KITTITAS COUNTY FIRE MARSHAL'S OFFICE

March 11, 2015

Re: WDFW HWY 10 (CU-14-00006 and SD-14-00003)

Upon review of the above mentioned land use action, I have the following comments/requirements;

HWY 10 ACCESS DEVELOPMENT

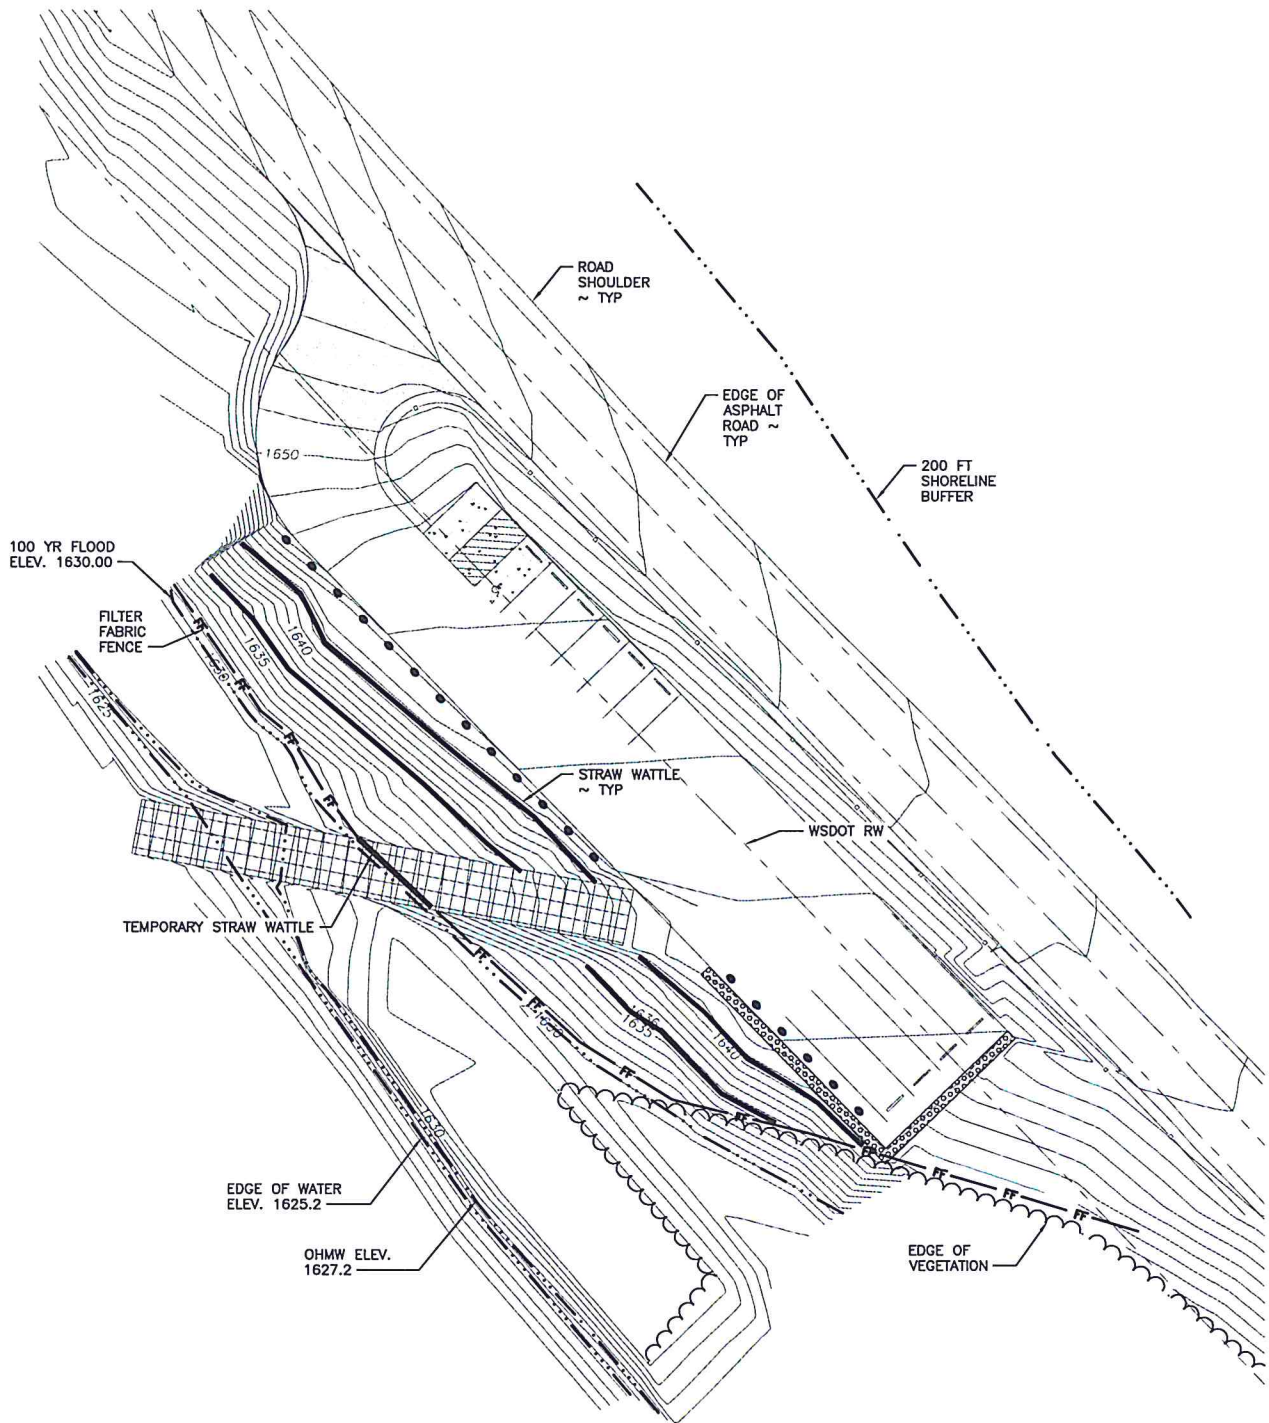
- A turn-around shall be provided for fire department access.
- Access shall be a minimum width of 20 feet.
- All development, design and construction shall comply with Kittitas County Code, Kittitas County Zoning and the most current version of the International Fire & Building Codes.
